APPLICATION UNDER SECTION 96A OF THE TOWN AND COUNTRY PLANNING ACT 1990 FOR A NON-MATERIAL AMENDMENT TO PLANNING PERMISSION 3/2017/0653 TO INCORPORATE REVISED LOCATION OF FOOTBRIDGE CROSSING AND BENCHES

LAND AT CHATBURN ROAD, CLITHEROE, BB7 2EQ

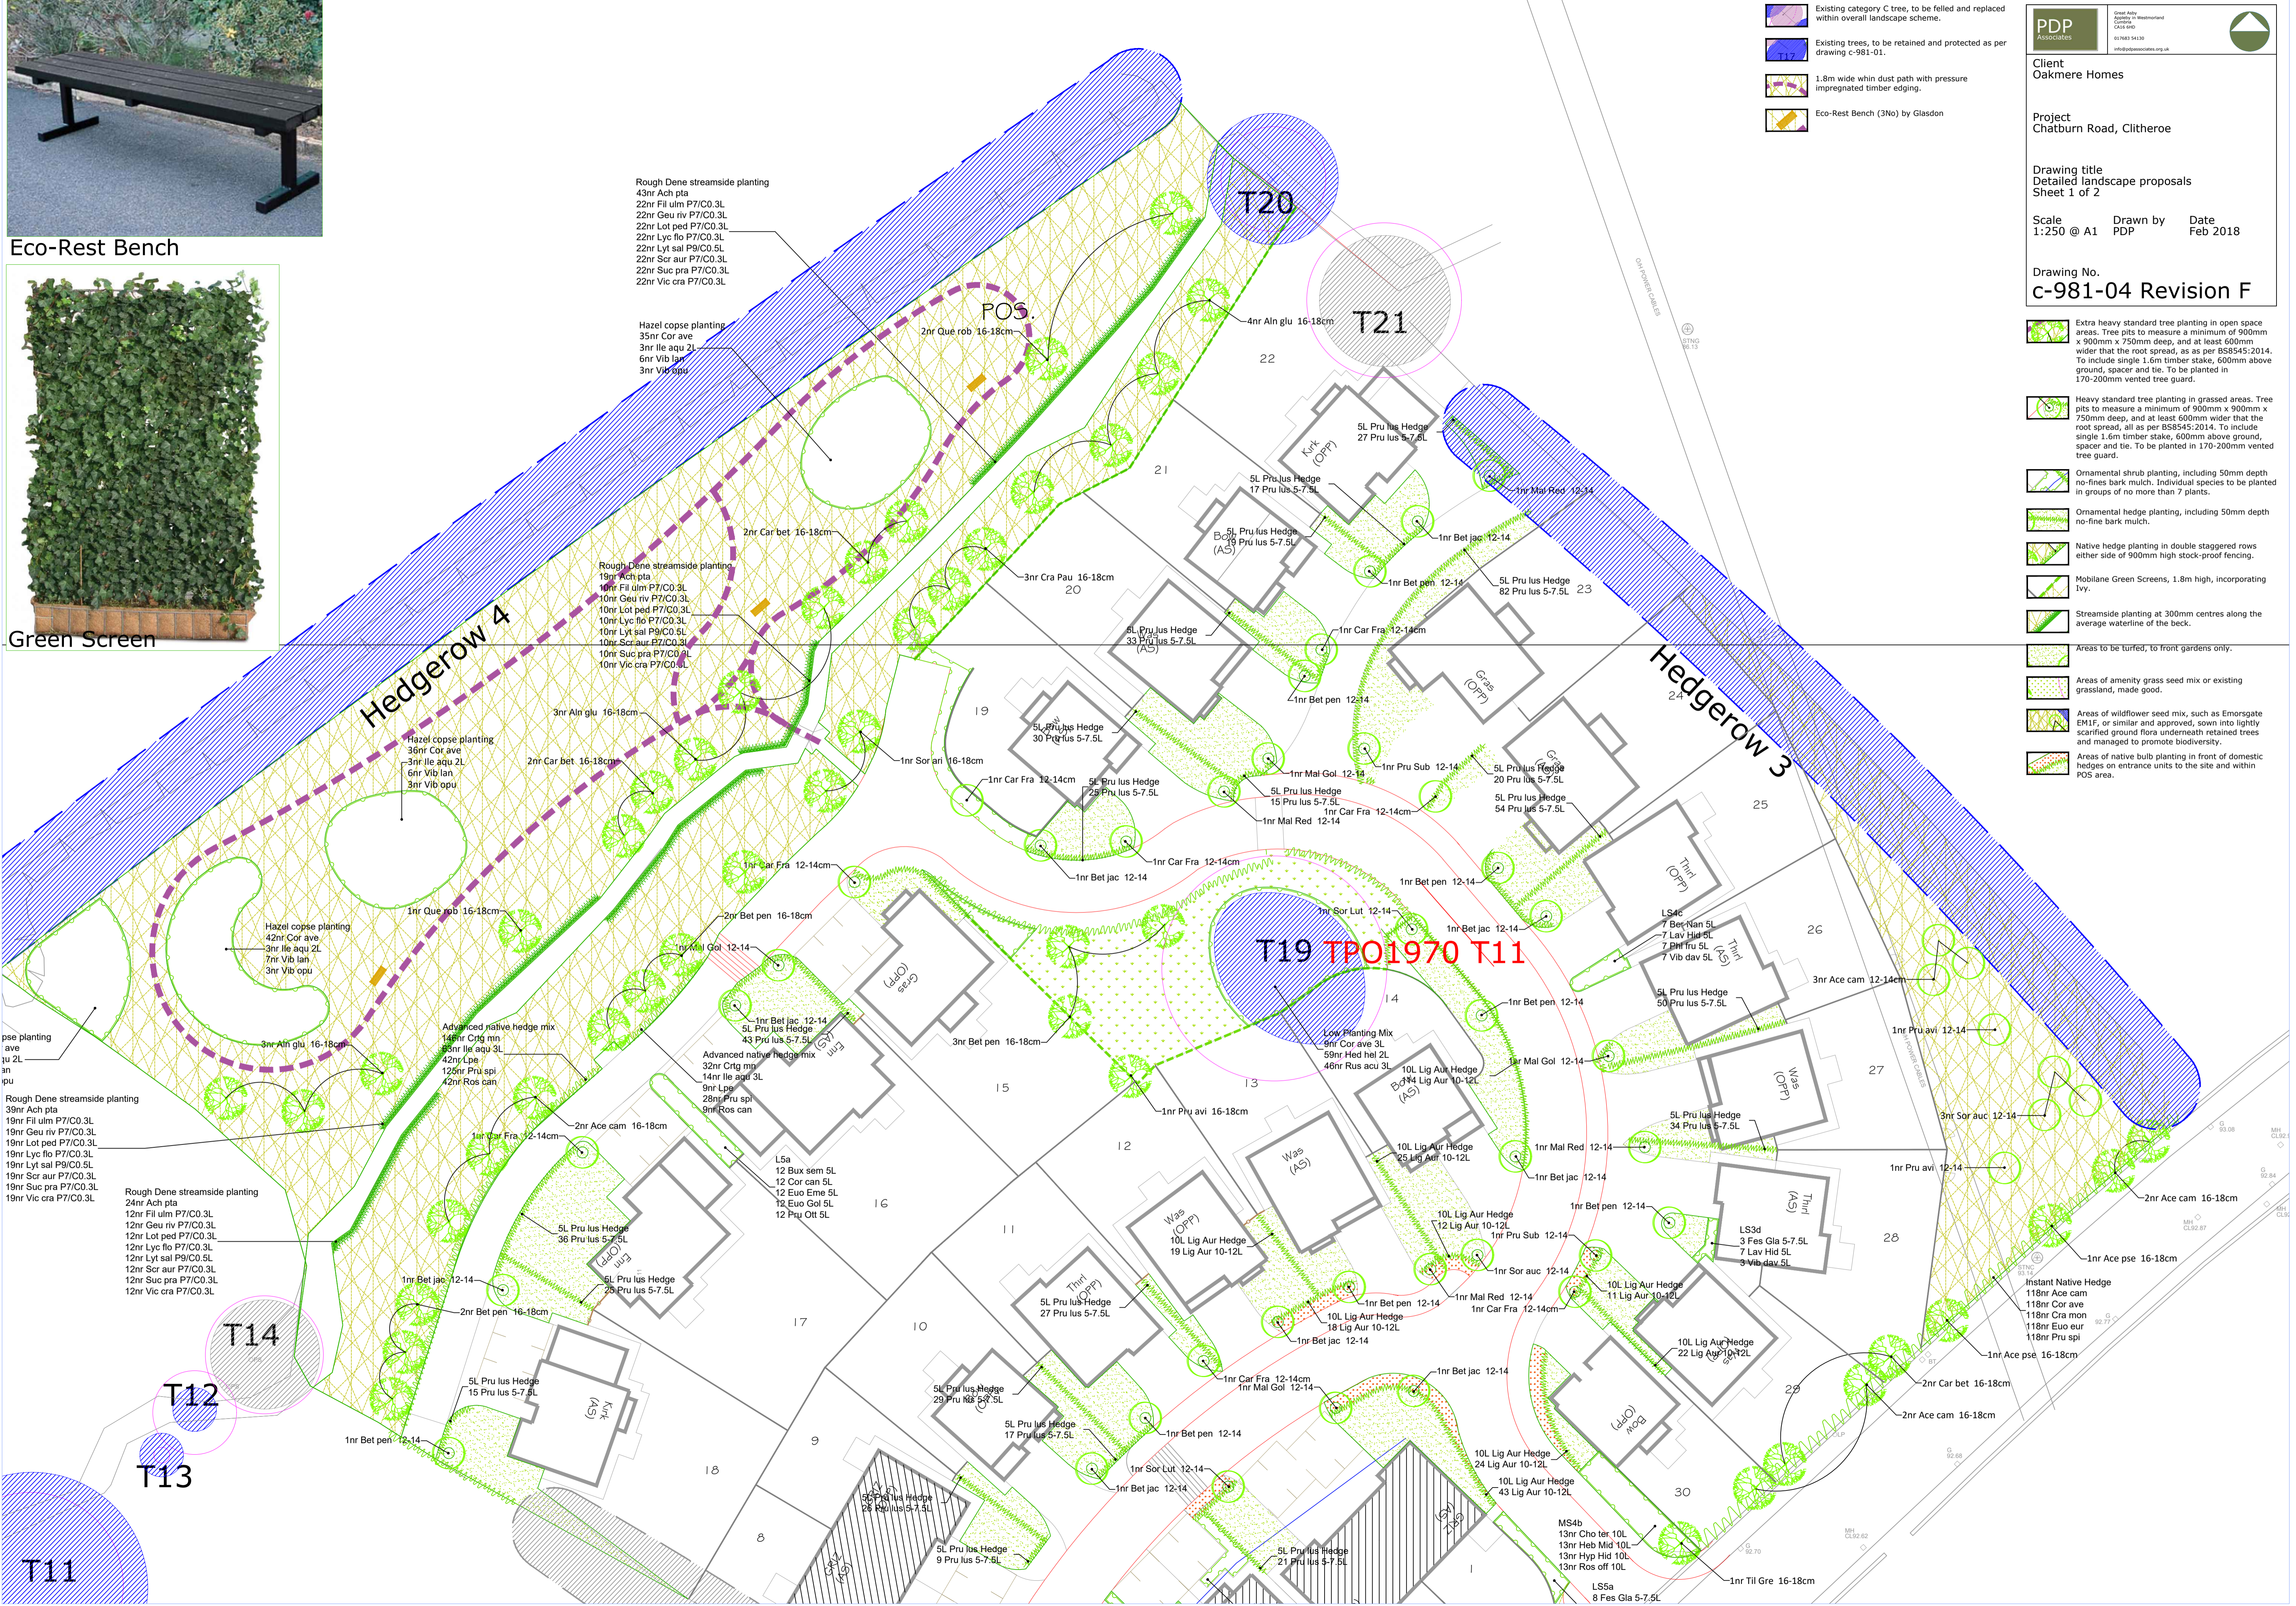
This application seeks to amend planning permission 3/2017/0653 to incorporate the revised locations of the footbridge crossing and benches within the public open space on site. The application comprises the following revised drawings:

- Drwg. 016/ENG/VBC (Proposal to Vary Footbridge Crossing)
- Drwg. c-981-04 Revision F (Detailed landscape proposals (sheet 1 of 2))
- Drwg. c-981-05 Revision F (Detailed landscape proposals (sheet 2 of 2))
